**Permit Number: BCOM2501-0012**

**Description: Convert garage to home bakery (No visitors)**

**Site Address: 134 HUMVEE CT**

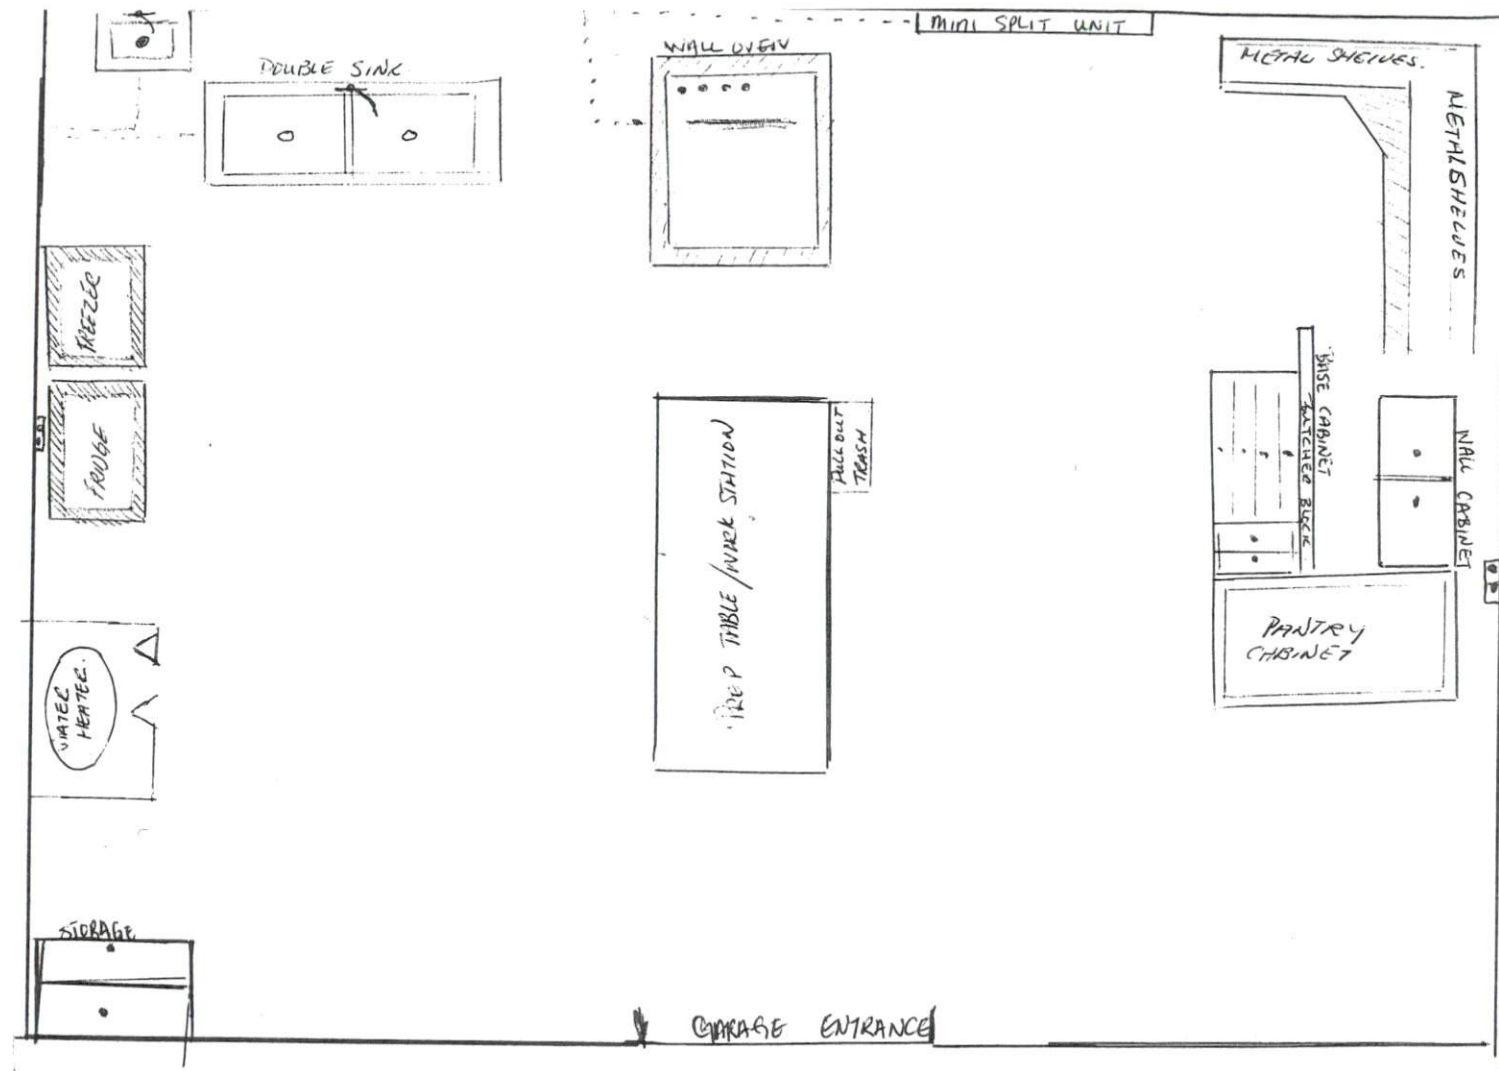
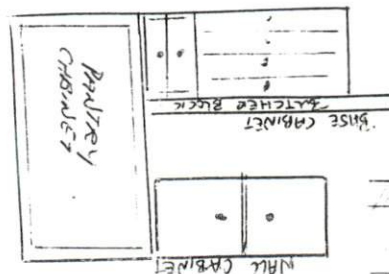
SENT DATE	RETURNED DATE	DUE DATE	TYPE	CONTACT	STATUS	REMARKS
Review Group: ALL						
7/1/2025	7/15/2025	7/16/2025	ENVIRONMENTAL	MARK OSBORNE	APPROVED	
Notes: permit to be drawn						
7/1/2025	7/8/2025	7/16/2025	FIRE MARSHAL	Roger Sullivan	DISAPPROVED	see notes
Notes: Not sure if you all needed to see this or not. She is doing this in her garage and no one will be coming to her home. - Need to submit "to scale" life safety plan drawing, to include measurements of garage, diagonal distance of garage, show exit doors locations, fire extinguisher placement & exit signs.
